DECISION DELEGATED TO DEVELOPMENT MANAGER

Application No: H14-0949-20 **Applicant:** A Leather
Proposal: Erection of detached self-contained annexe
Location: Warblers Nest Iron Bar Drove Spalding
Terminal Date: 30th December 2020

Block Plan

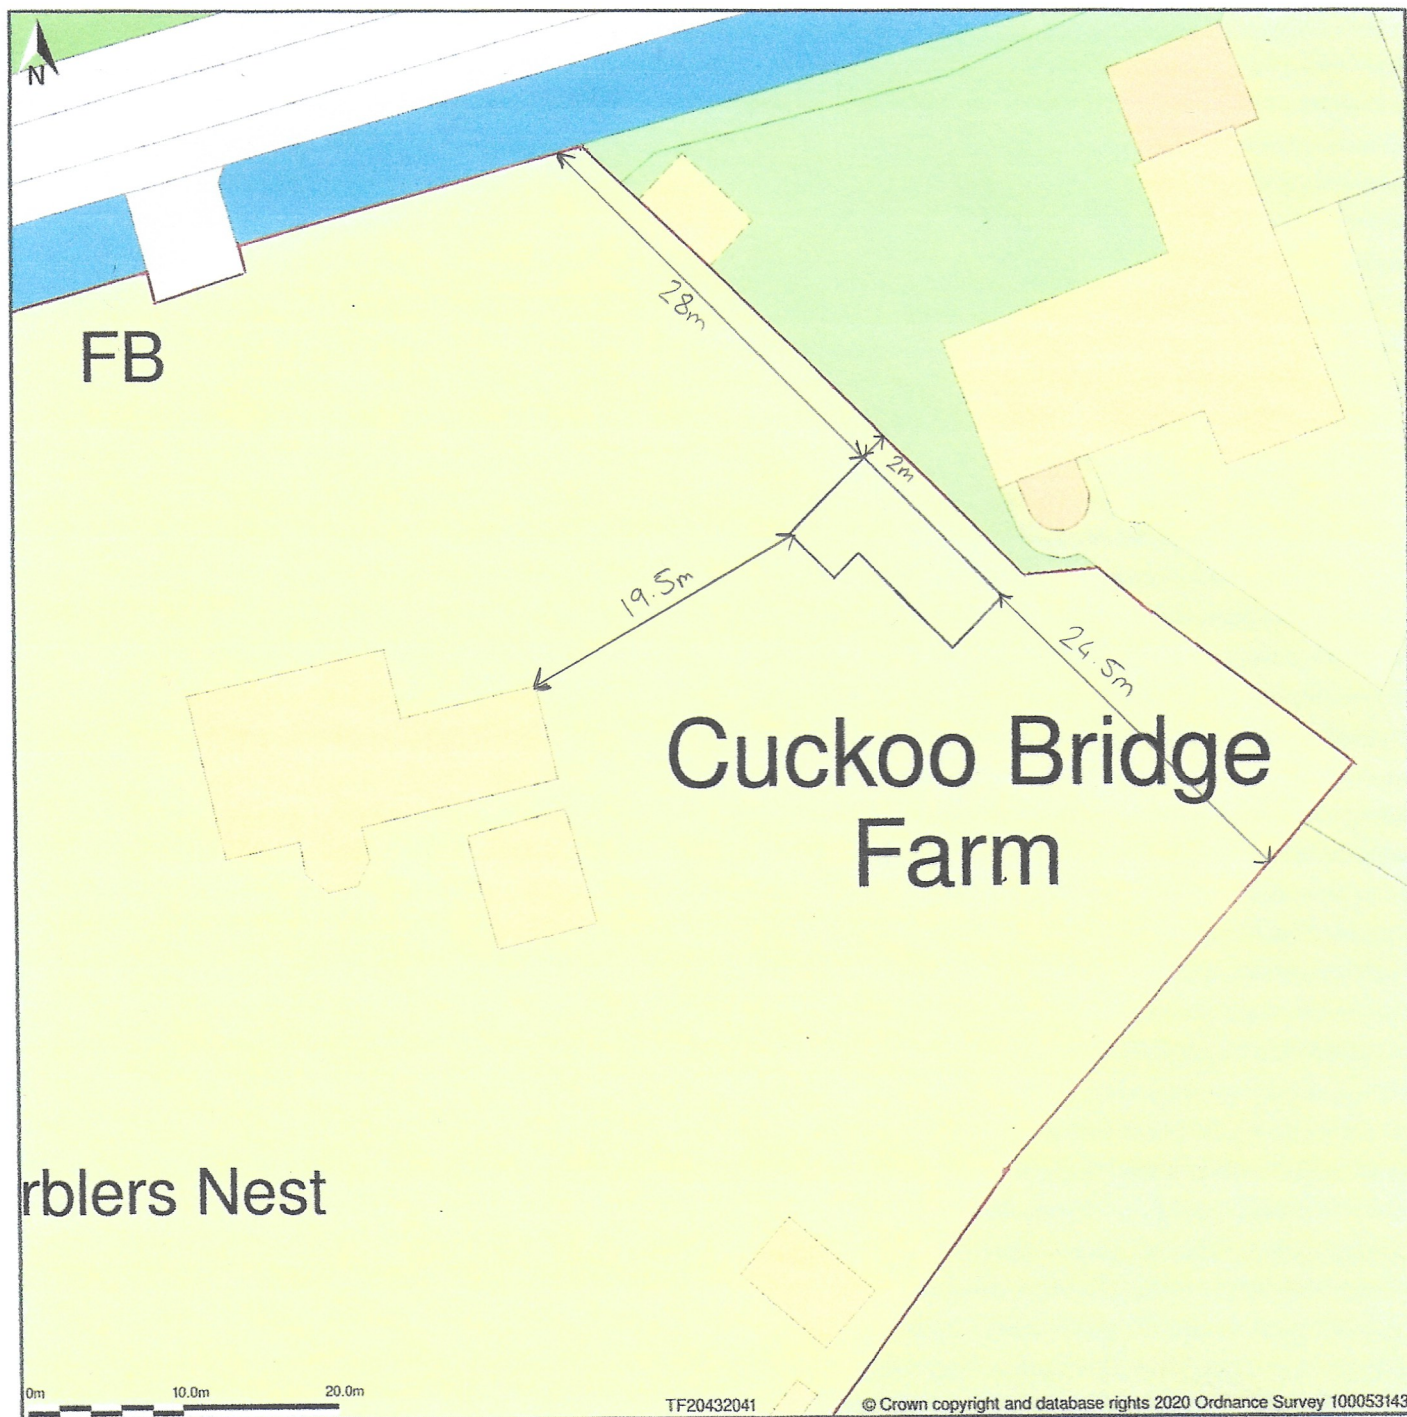
The proposed annexe has a separation distance to the north-western boundary of 28 metres, to the north-eastern boundary of 2 metres, 19.5 metres to the dwelling to the south-west and 24.5 metres to the south-eastern boundary.

The proposal is for a two bedroom annexe, with a shower room, kitchen and living room. The proposed annexe would be subordinate to and detached from the main dwelling at Warblers Nest, and will be situated to the east of the site. The curtilage of the property is large and more than adequate to accommodate an annexe of this scale.

The overall appearance of the annexe is a flat roof design with cedar lap cladding to the exterior walls. A flat roof design is not typically favoured, however the annexe will be set well back from the road and will be screened by the conifers to the front of the property.

In terms of amenity, there are few immediate neighbours other than the farm to the east and another to the north west. There is approx 1.8m high closeboard fencing between the site and the property to the east. It is considered that the amenity of nearby residents would not be materially harmed in terms of overlooking, lack of privacy, overbearing effect or overshadowing due to the single storey nature of the annexe and the proposed separation distance (4.8m at the closest point).
